From: Chris Alger [REDACTED]
Sent: 24 October 2019 18:02
To: Neil Crowther
Cc: Anita Gardner
Subject: Fwd: Planning Application M/80/19/PL

Ref- Planning Application M/80/19/PL

I would like to **STRONGLY OBJECT** to the above planning application for the following reasons-

Drawing no: PJC/5256/19/B	Rev: -	Sheet number: 1 of 4
Client and site: Edmonds Williams Ltd		
Yapton Road Middleton-on-Sea PO22 6SE		
Drawing title: Tree Retention Plan		
Date drawn: 28/08/2019		
Scale: 1:200 at A3		
Drawn by: LR	Checked by: PD

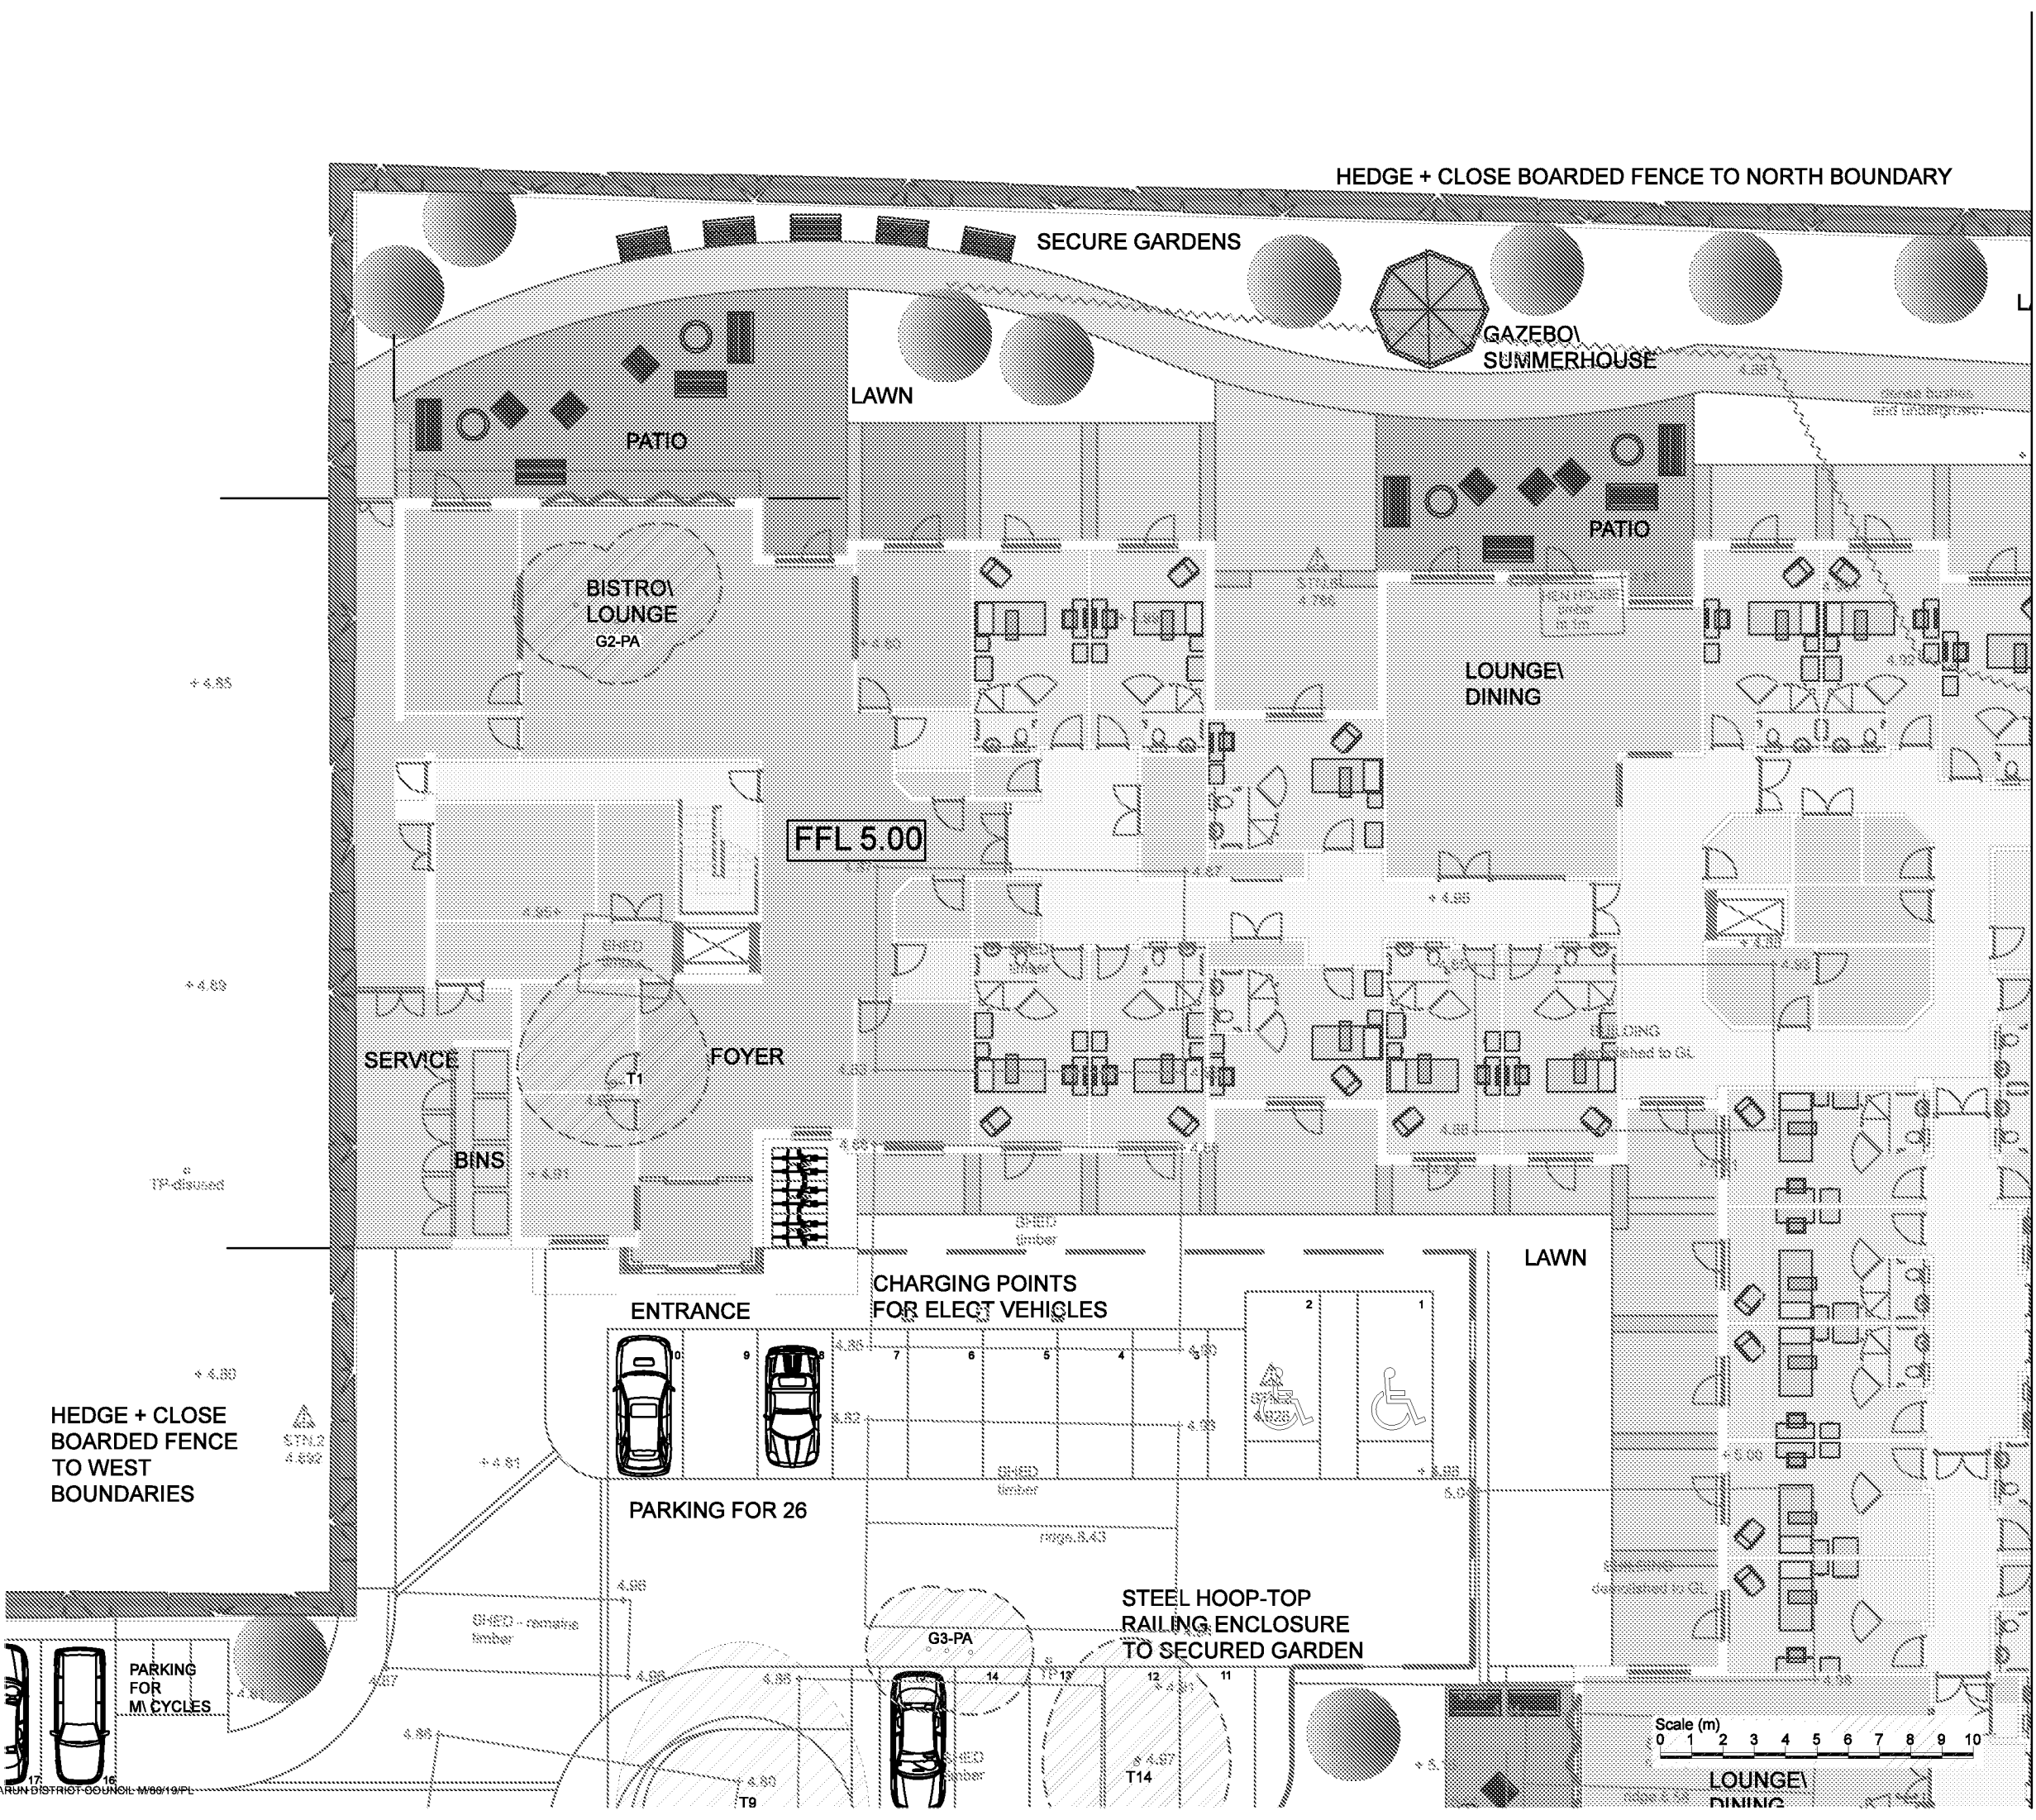
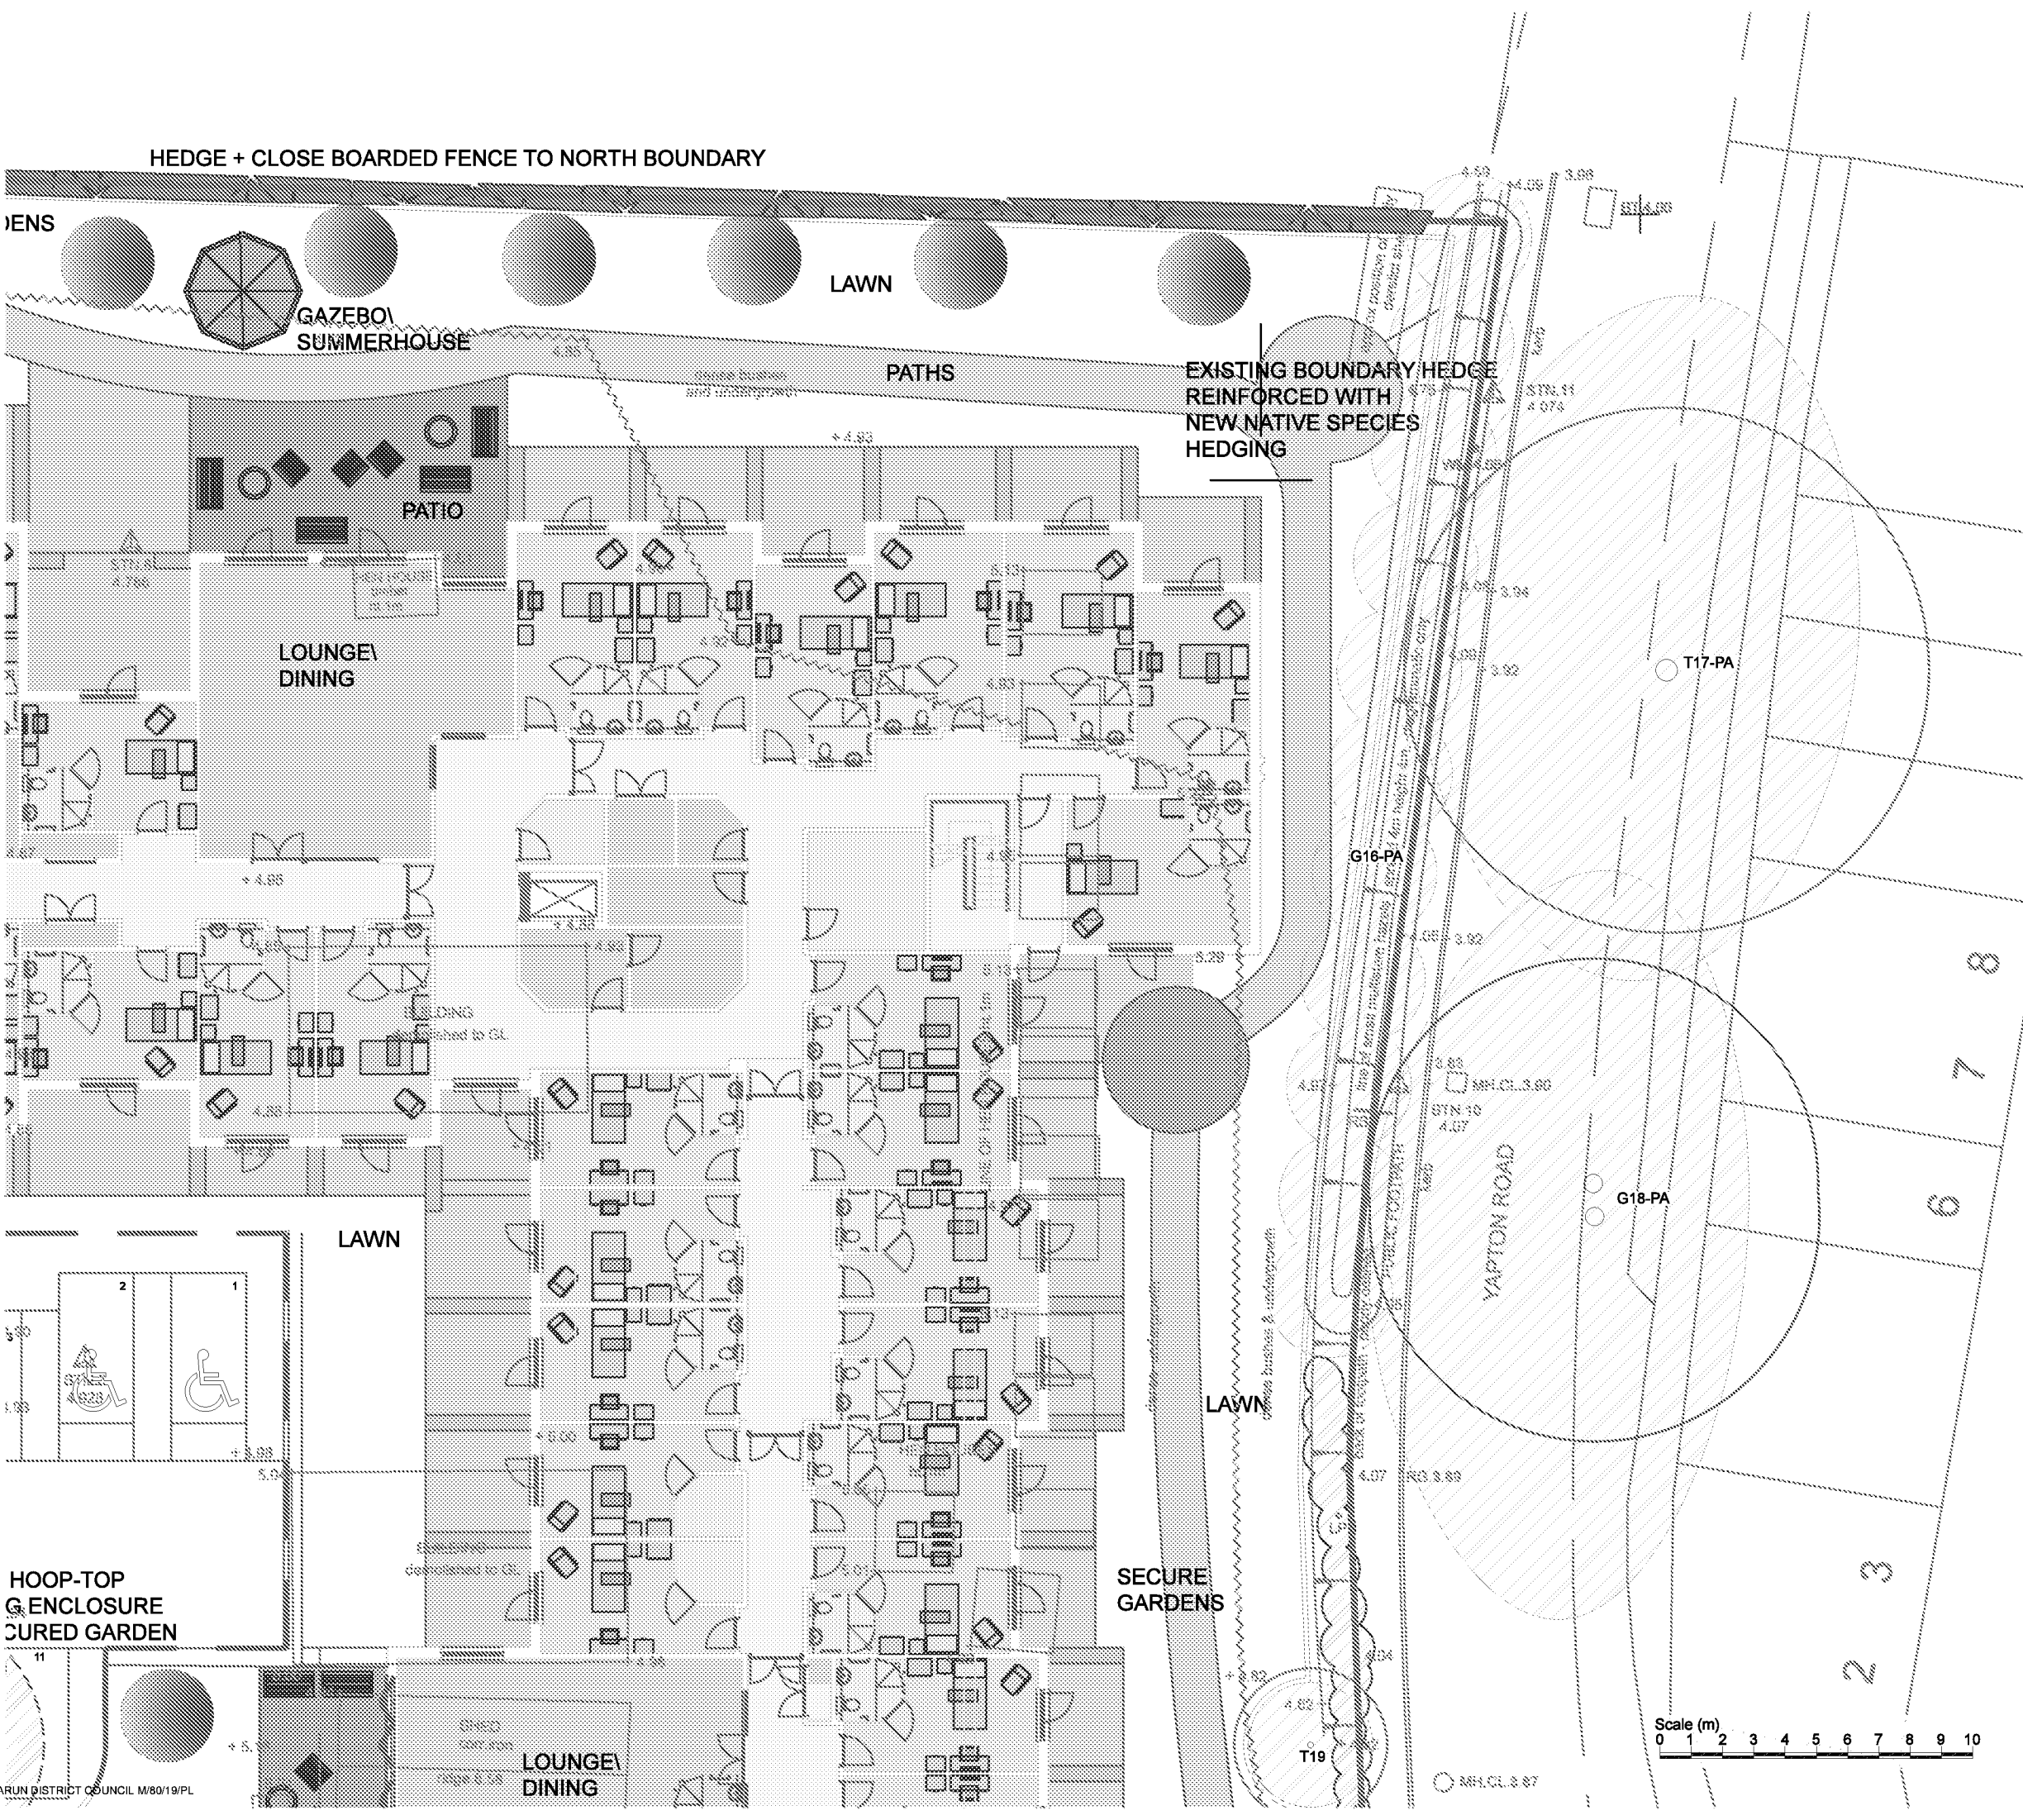
Not only is the proposed access road too narrow, but it is also impossible to construct without causing serious damage to three protected trees (TPO/M/1/15).

The road cannot be built without damage or even fatal destruction of these trees as large commercial vehicles and numerous cars and vans drive-over the roots 24/7 365 days of the year. A tree preservation order should mean exactly that - we keep it unharmed and safe.

There is no way that access can be gained without trimming a large number of branches from these trees which of course Frontier Estates will need planning permission. I note that they are not doing this now as it could prove to be far too controversial, although at the public exhibition in August they admitted this would be necessary?

It is totally wrong to mislead the public now at this planning stage. There is just no way any of these protected trees can survive should this plan go ahead?
